LAND USE PLAN - COVER
SHEET 01 OF 04

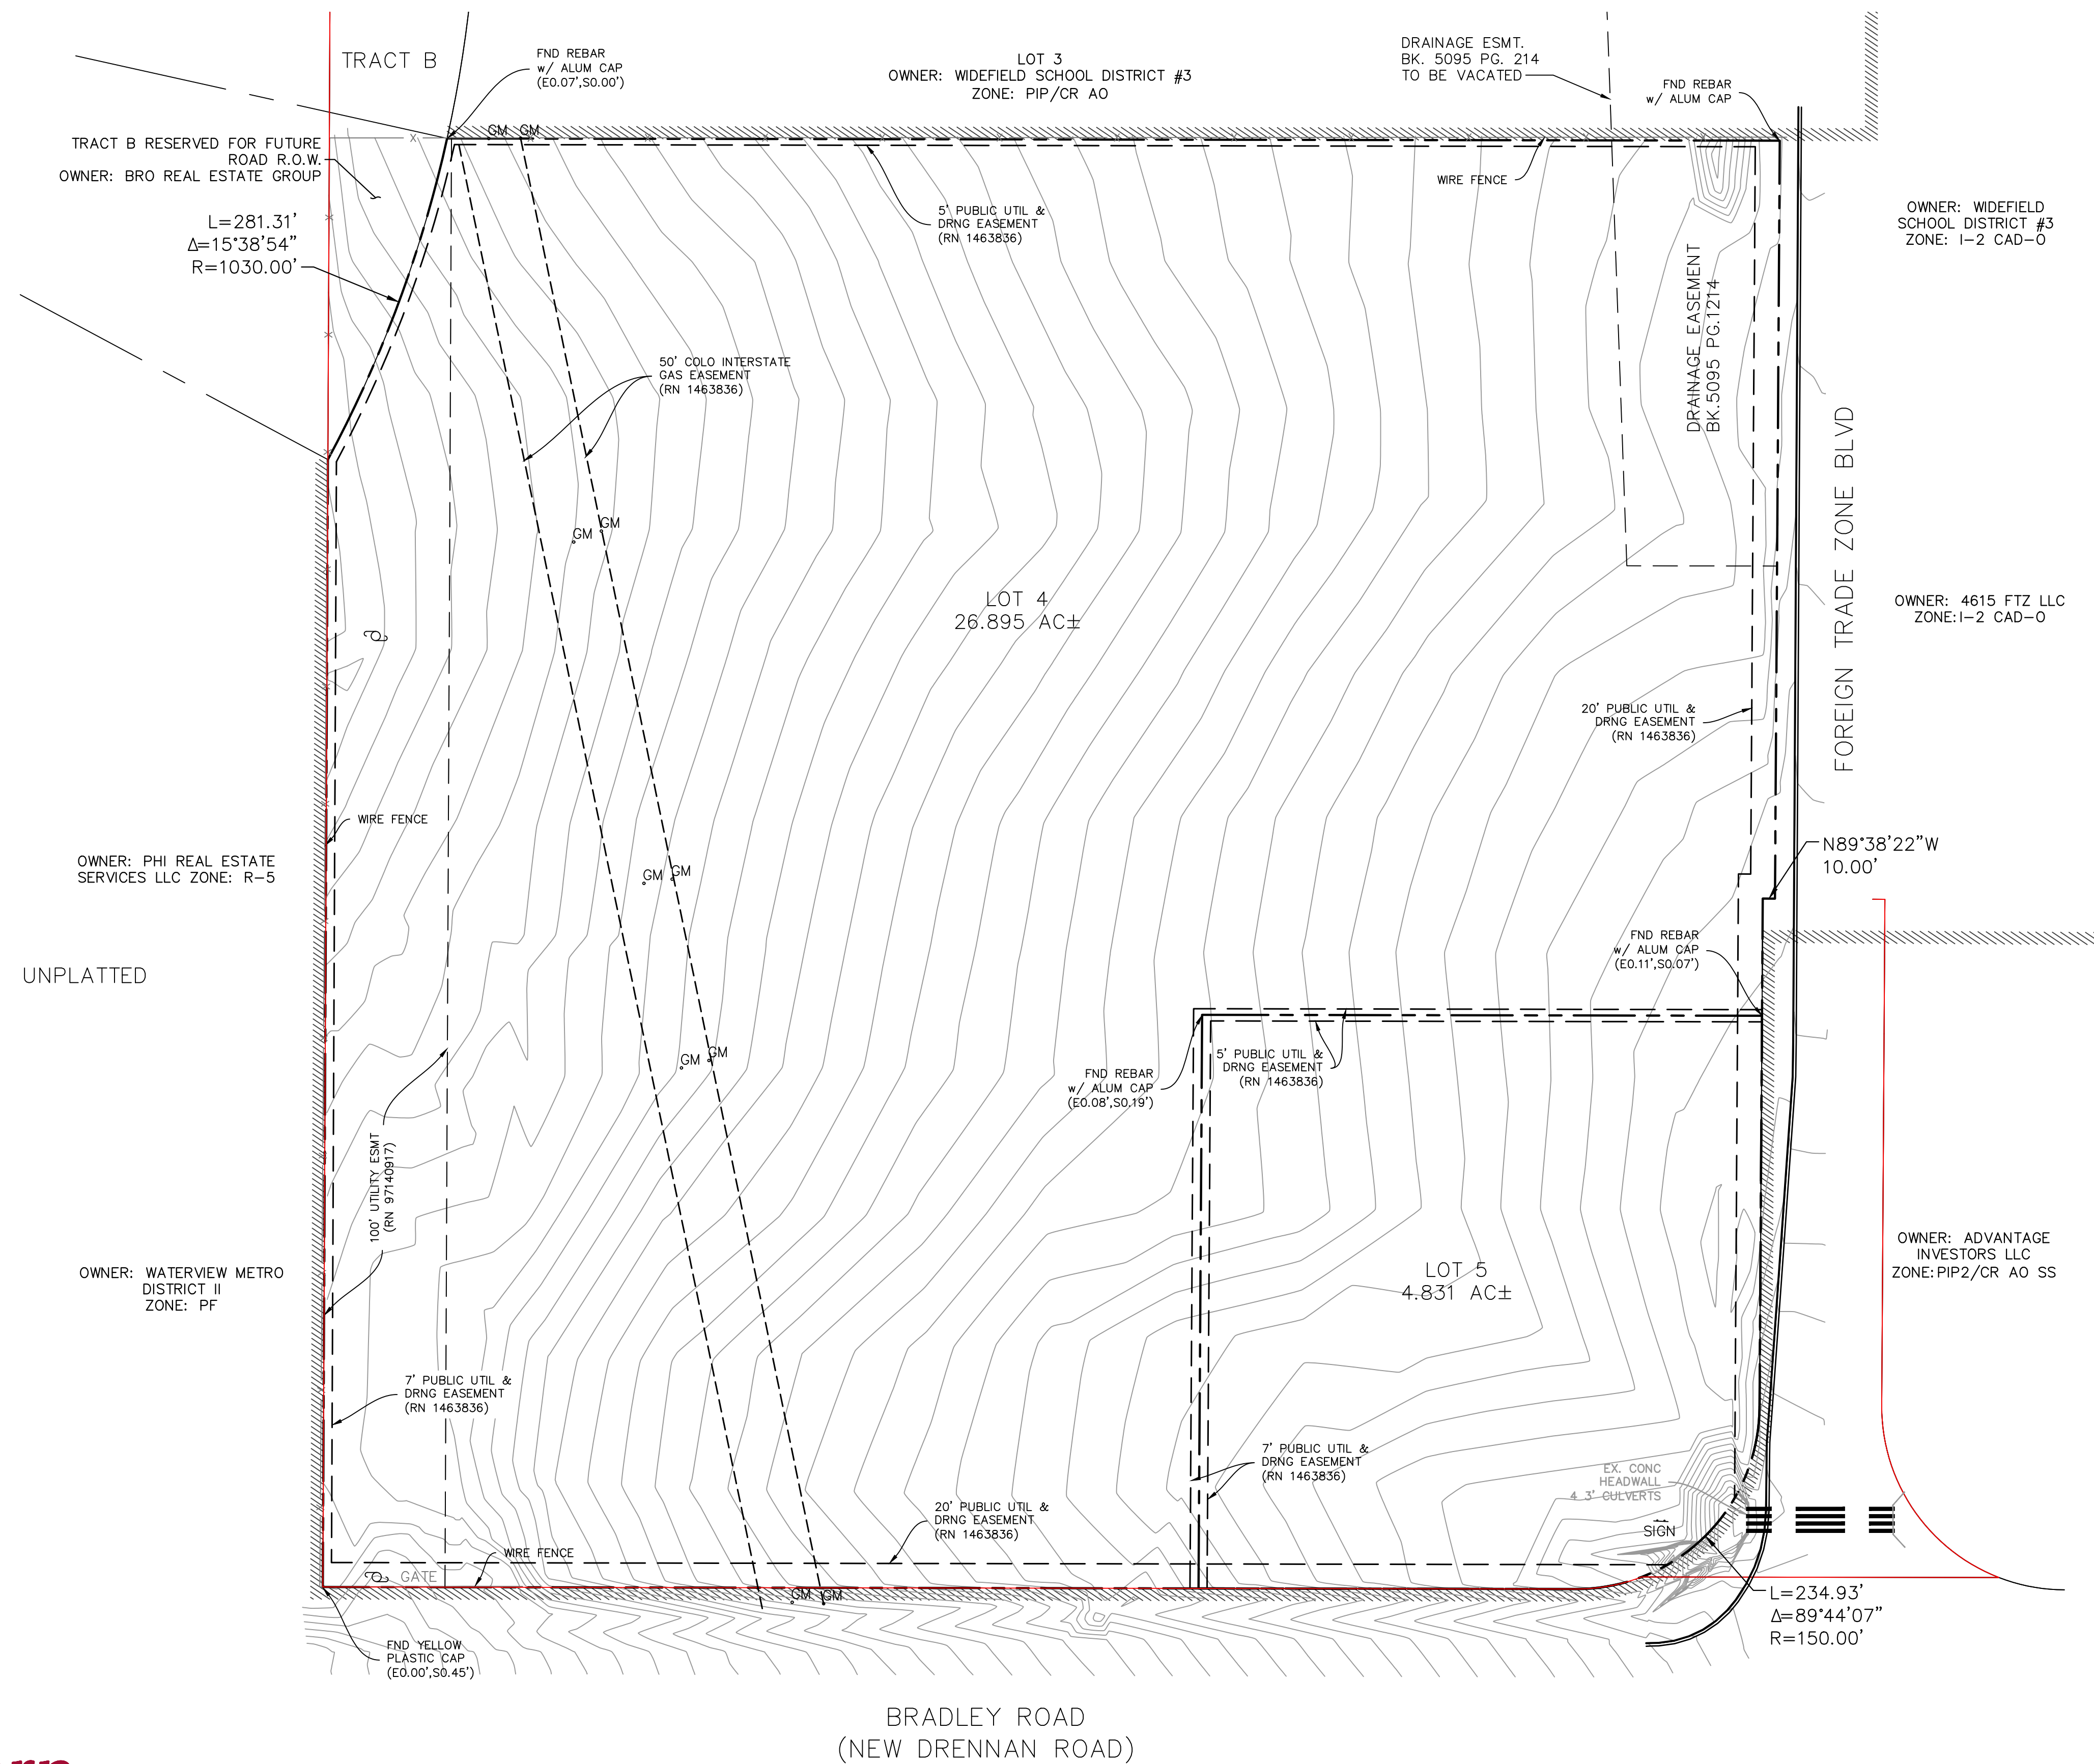
- a. Vicinity map with adjacent streets and drainageways labeled must be shown on cover sheet.
- b. FEMA floodplain statement must be included as a note on the cover sheet. Note must include current map number and effective date.

- c. Note indicating long-term maintenance responsibility (private vs. public) for water quality / detention facility(ies) must be included. If facility is located offsite, include name of facility and a reference to the final drainage report containing calculations for the offsite facility.

- d. Note calling out channel improvement requirements associated with the site, including responsible party, long-term maintenance responsibility (private vs. public), and timing requirements (e.g. *Channel improvements will be designed and constructed or assurances for channel improvements will be posted prior to building permit issuance for {developments}, and channel improvements must be constructed and accepted into probationary acceptance prior to CO release for {developments}. All channel improvements will be completed in accordance with current Drainage Criteria Manual and DBPS requirements.*) must be included.

Notes have been added to the cover sheet from the land use plan checklist.

LAND USE PLAN - EXISING CONDITIONS
 SHEET 02 OF 04

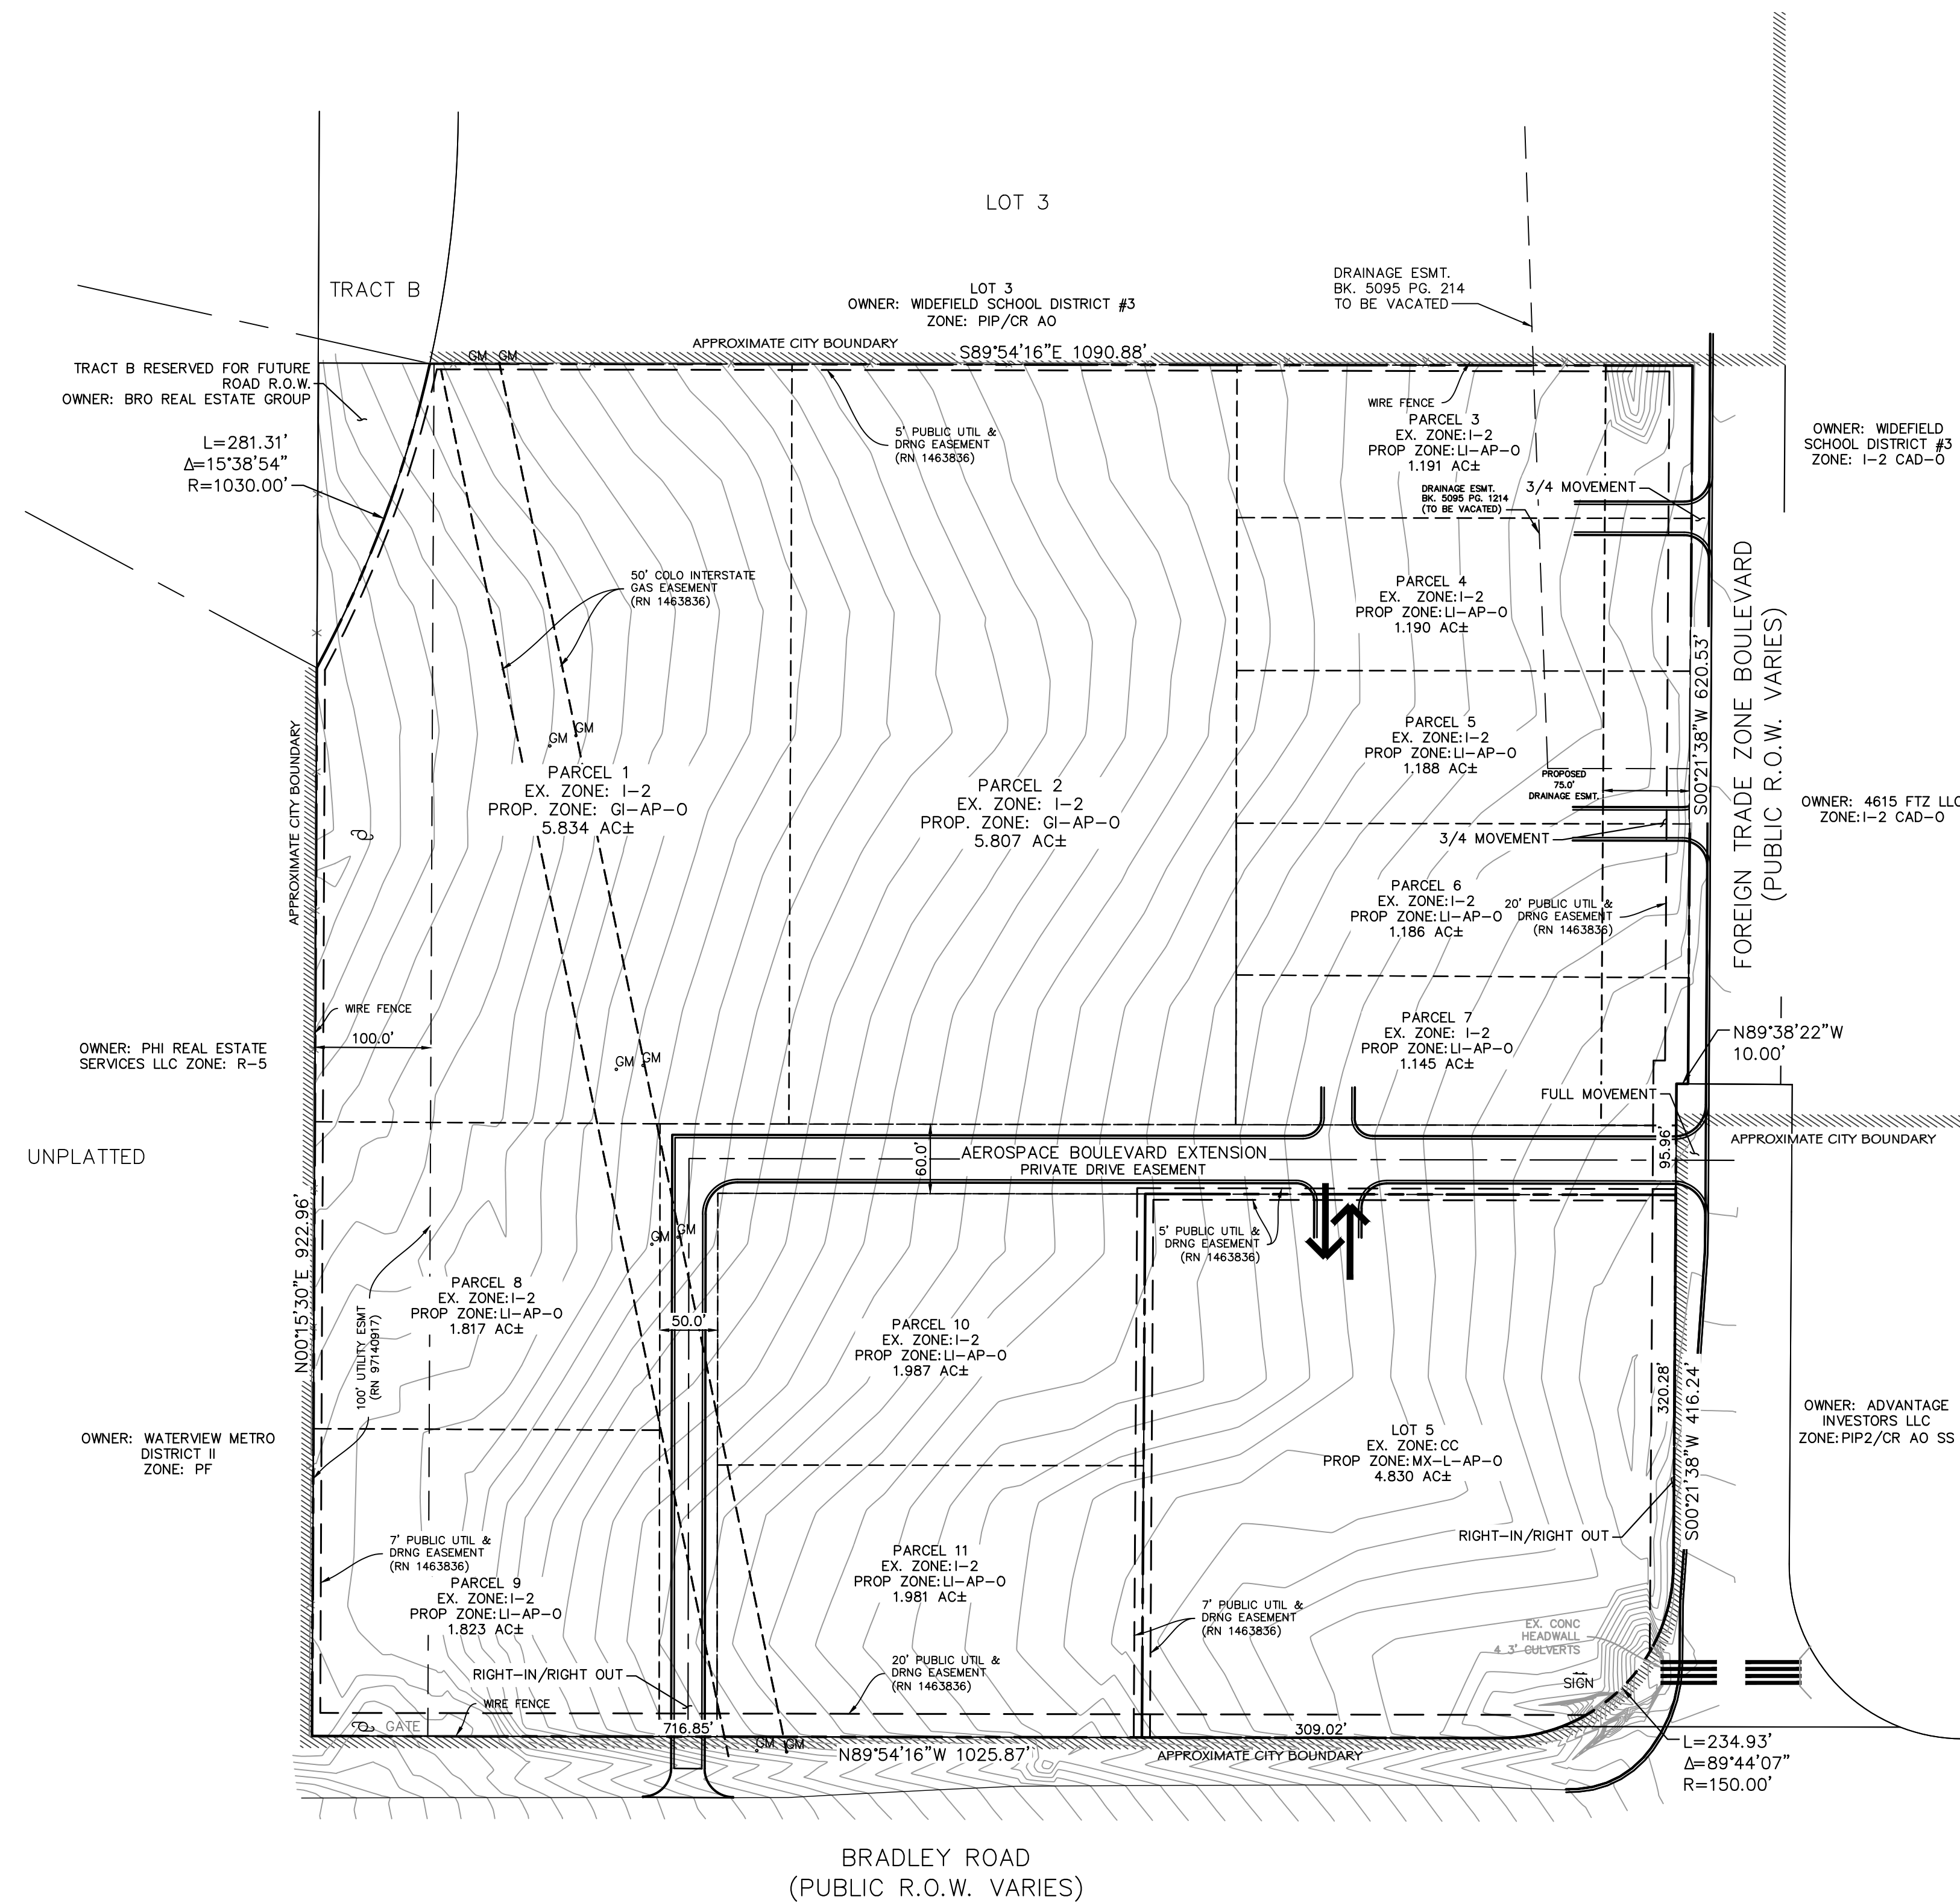
- a. All existing storm infrastructure, open channels, irrigation canals, and bodies of water must be shown and labeled on plan.
- b. General location of water quality and detention facility(ies) must be shown and labeled on plan.
